LEGACY CHURCH - GREEN MOUNTAIN FALLS, CO DEVELOPMENT PLAN

COVER SHEET
SHEET 1 OF 13

OVERALL SITE PLAN
SHEET 2 OF 14

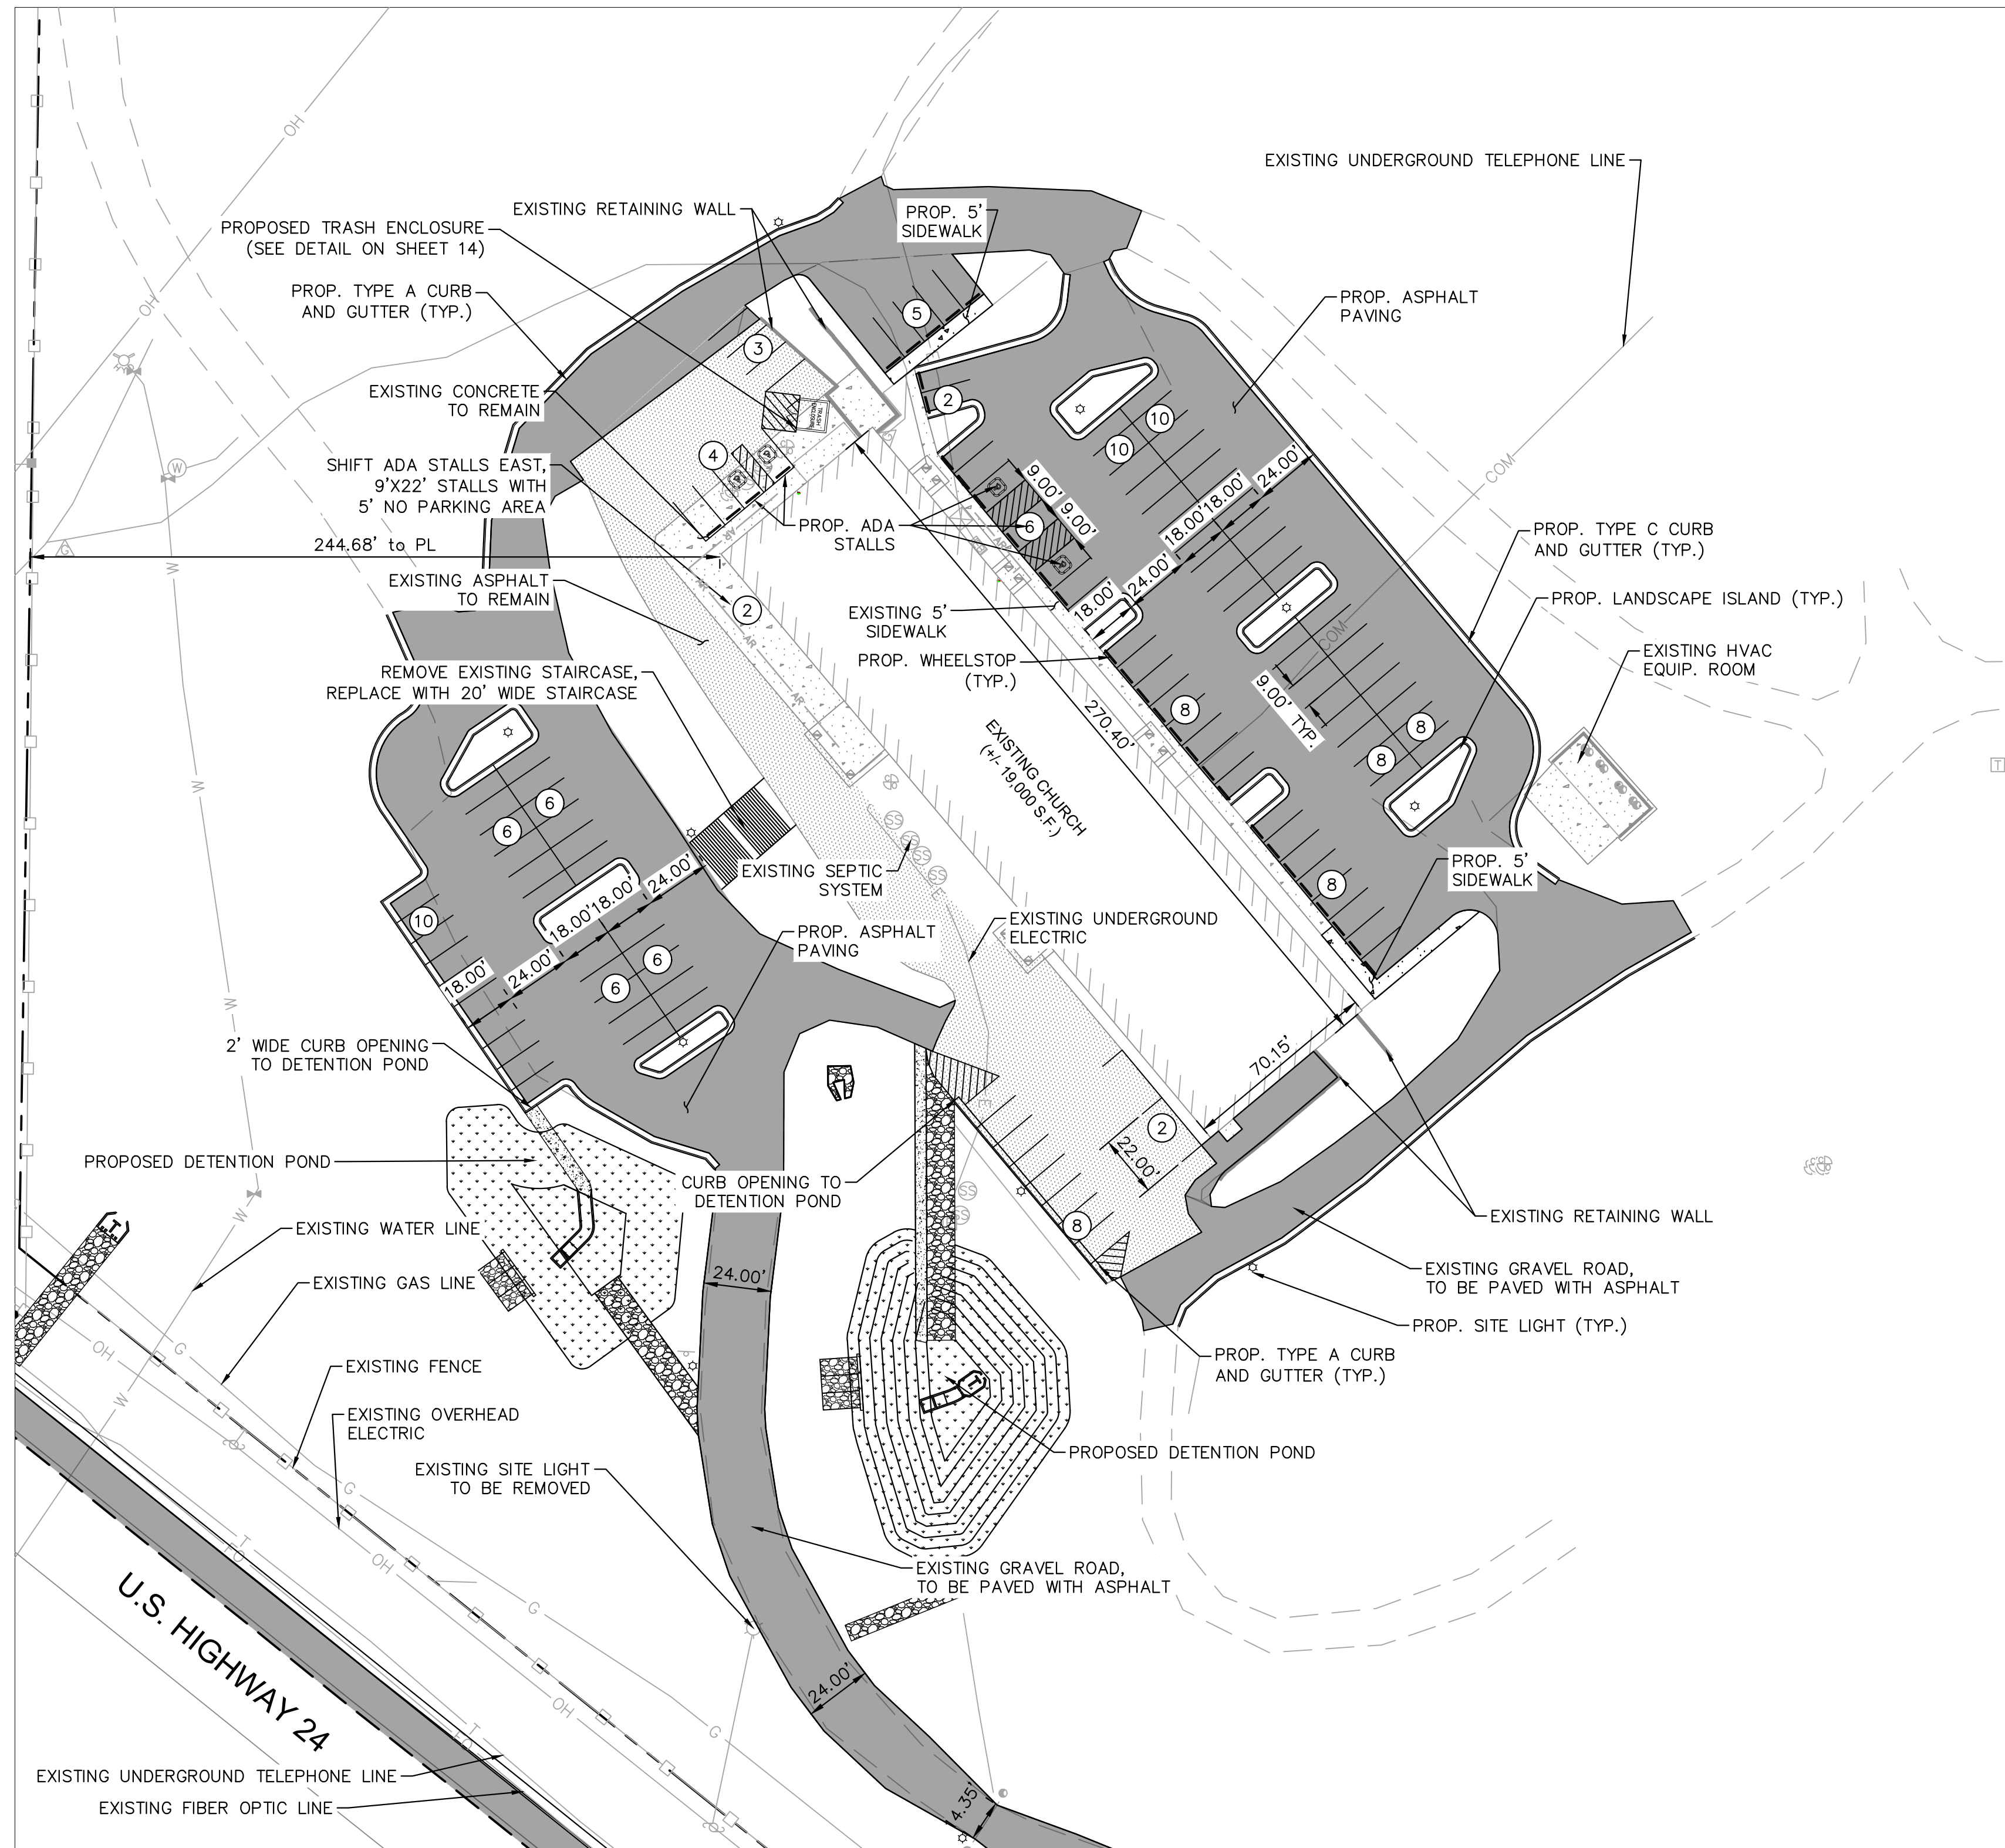
Per the El Paso County Assessors web page, The site as shown is 3 parcels instead of a single parcel. Delineate the property line of each parcel.

Please provide a project summary with information such as: property parcel number(s), address, zoning, lot size, sq.ft of church building, capacity/seats of church/sanctuary etc.

Provide the parcel number or name and address of adjacent property owners.

The traffic study indicates that deceleration and acceleration lanes are required. Please show the line work of the proposed lanes. A call-out may be added to refer to construction plans submitted to CDOT.

Once construction plans/access permit has been approved by CDOT, staff asks that the CDOT approved documents be uploaded for our records.

REQUIRED PARKING: 1 STALL PER 4 SEATS, OR 125 STALLS
 PROPOSED PARKING: 125 STALLS
 REQUIRED ADA STALLS: 5
 PROPOSED ADA STALLS: 5
 Break out the number of standard ADA and Van Accessible stalls provided.
 Please indicate the amount of seats/capacity of the church

Please add the following note:
 The parties responsible for this plan have familiarized themselves with all current accessibility criteria and specifications and the proposed plan reflects all site elements required by the applicable ADA design standards and guidelines as published by the United States Department of Justice. Approval of this plan by El Paso County does not assure compliance with the ADA or any regulations or guidelines enacted or promulgated under or with respect to such laws.
